From: Martyn White
Sent: 31 August 2018 11:24
To: Planning.Responses
Subject: BR/203/19/L and BR/204/18/PL

BR/203/19/L and BR/204/18/PL

Bath House is a 1820s villa over 3 storeys with a basement. It is painted render with sliding sash windows. It is a Listed Building and is located within a Conservation Area. The proposals therefore have the potential to affect two heritage assets.

Drawing Title:
PROPOSED PLAN AND SECTIONS
FLAT 6

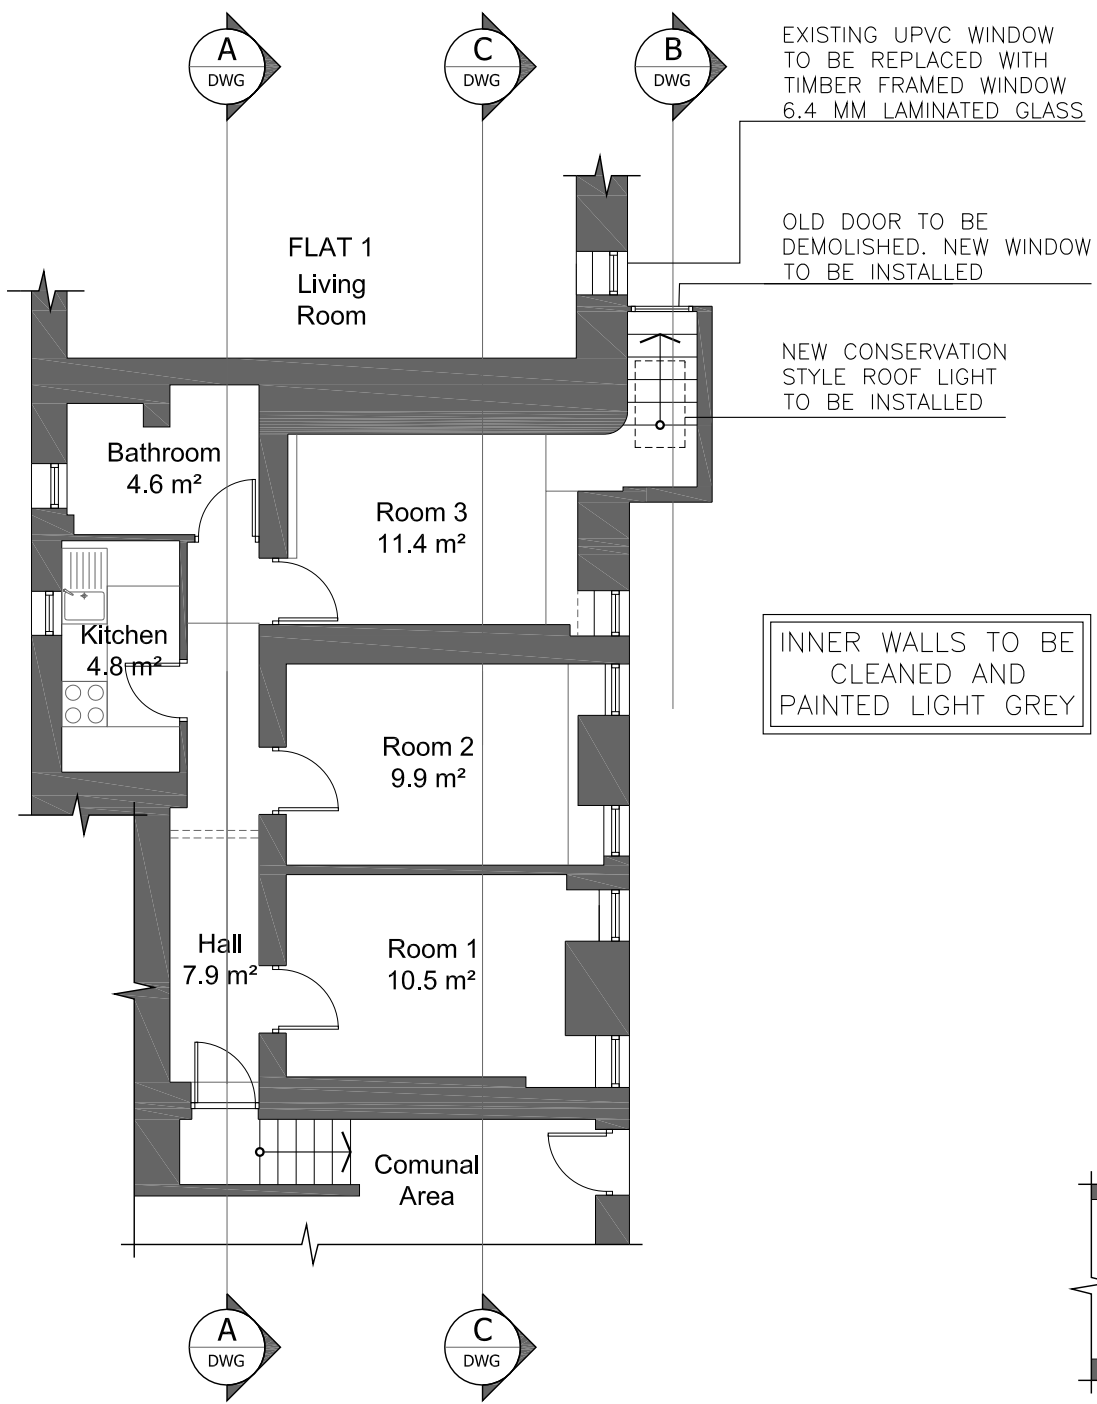
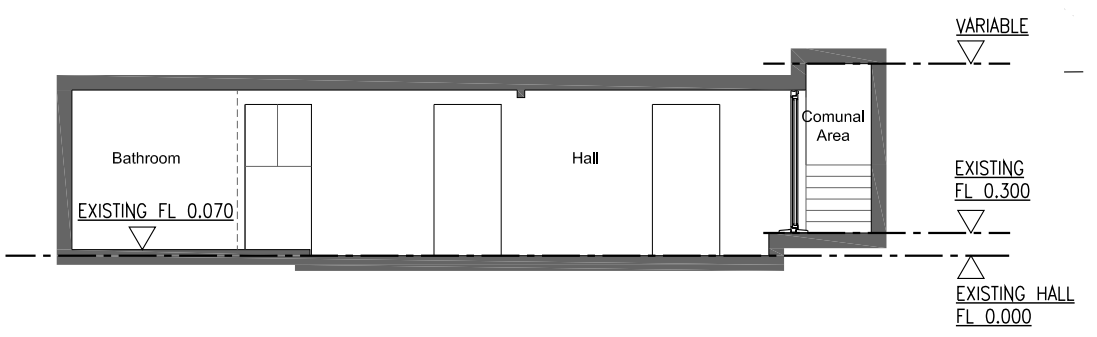
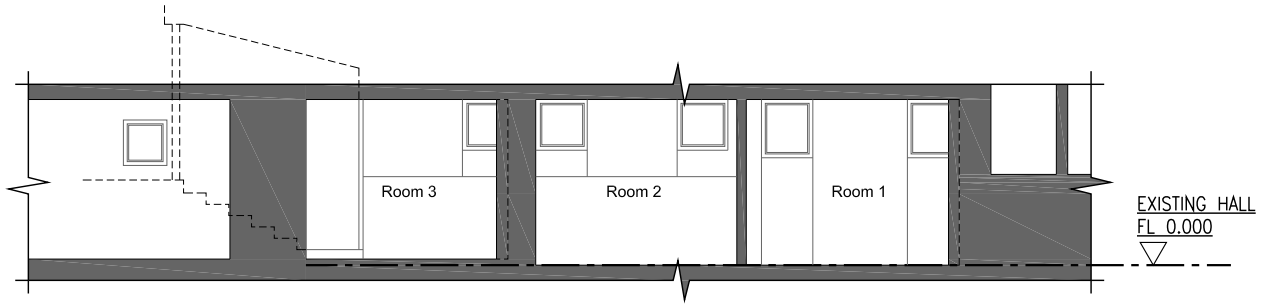
The side passage is visible from the Steyne and the proposed replacement of the boarded door to flat 6 with a window and masonry is considered will have a positive impact upon the appearance of the listed building. However, it is not clear what the proposed windows will look like (timber framed sash window?), and details will need to be provided by way of condition. It is considered that the installation of a flush roof light will not be visible from the conservation area, and not cause any significant harm, and can be supported.

Flat 6 is in a poor state of repair, and is not habitable in its current state. The proposals will see it brought back into active use. The works to flat are intrusive, the applicant states that this is viewed against a background of evidence of significant modification sometime in the past through the provision of new internal walls and other changes. A significant damp and mould problem is present and the works propose to deal with these issues, whilst allowing the building to breath. Whilst substantial in nature, it is considered that the works will allow the space to be brought back into use, which is a positive approach. Therefore on balance, the works are considered acceptable.

PROPOSED PLAN AND SECTIONS
FLAT 5

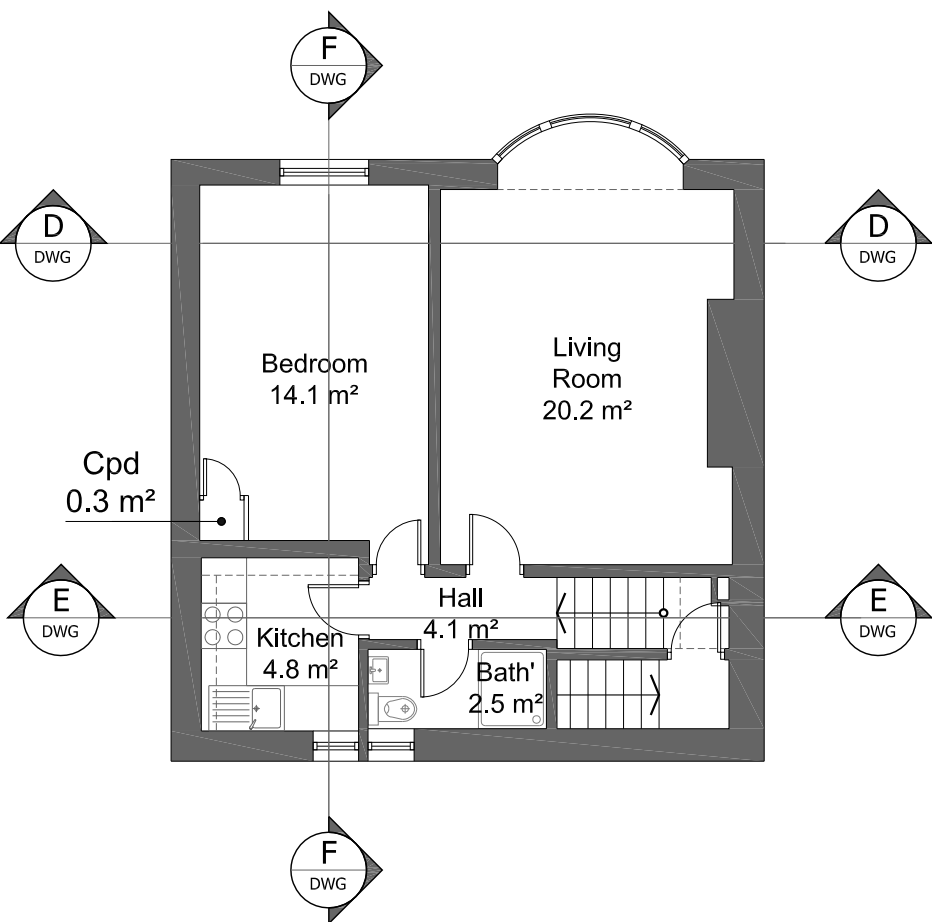
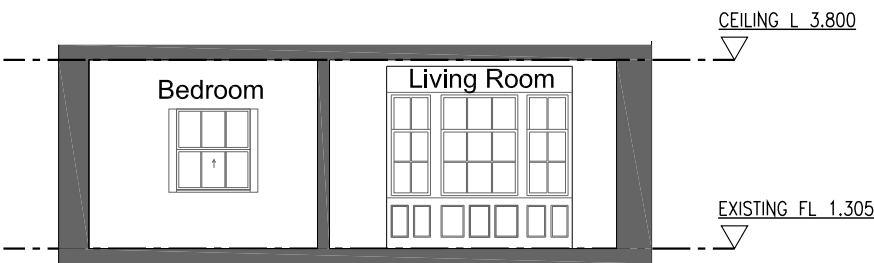
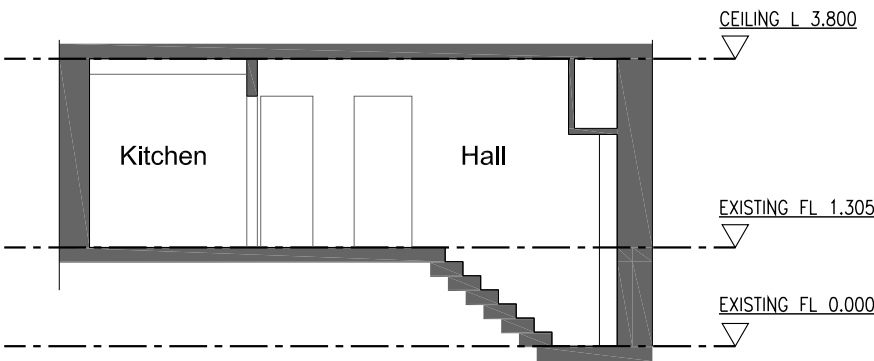
Works to flats 1 and 5 are supported as it all considered will affect modern fabric and as a result, have a neutral impact on the character of the building.

BIN STORE
PROPOSED PLANS, ELEVATIONS, SECTION

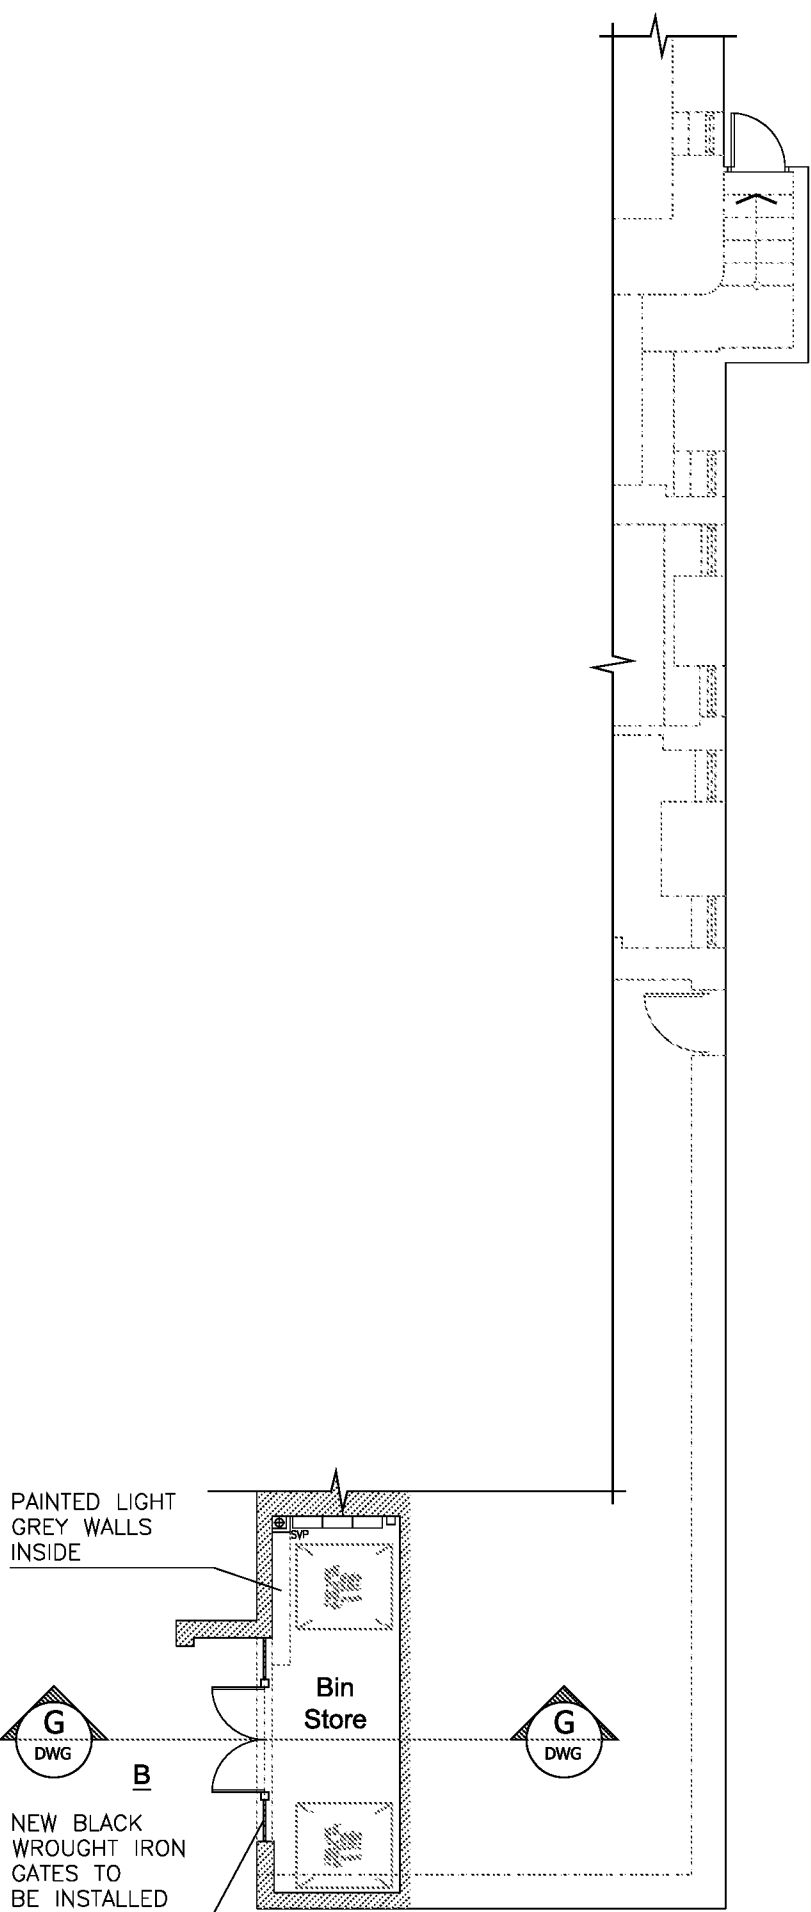
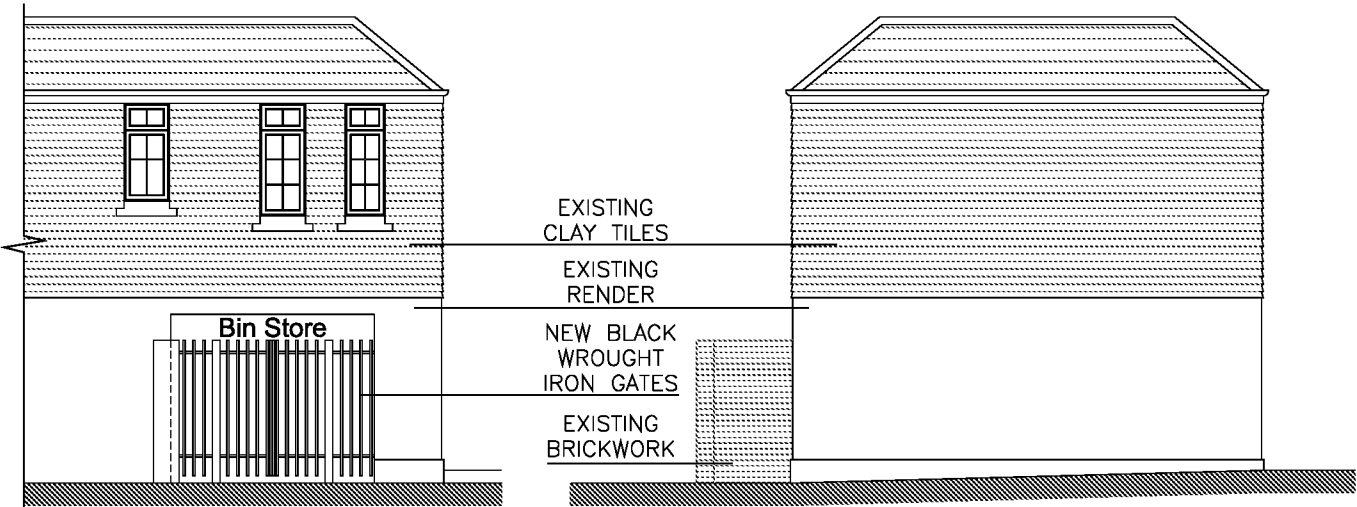
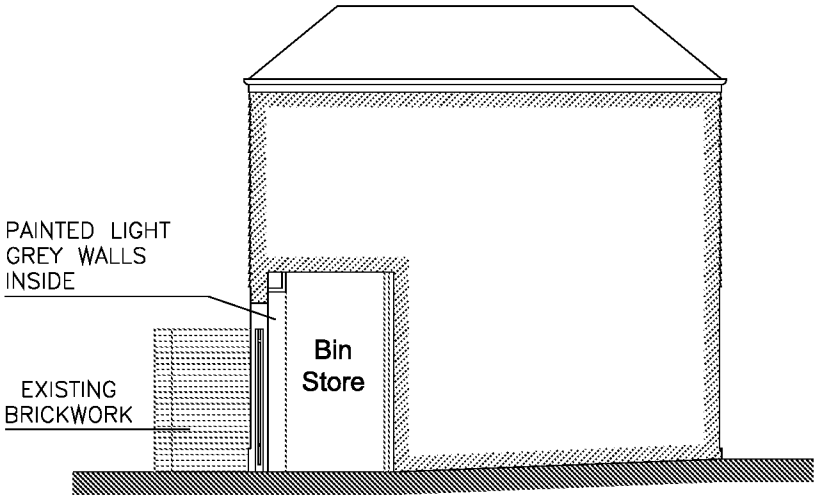
The external works also include the provision of a wrought iron gate to the bin store. This is supplemented through the area being cleaned and painted in order to improve its appearance. It is considered that such a proposal is acceptable, subject to further information related to the appearance of the gates.
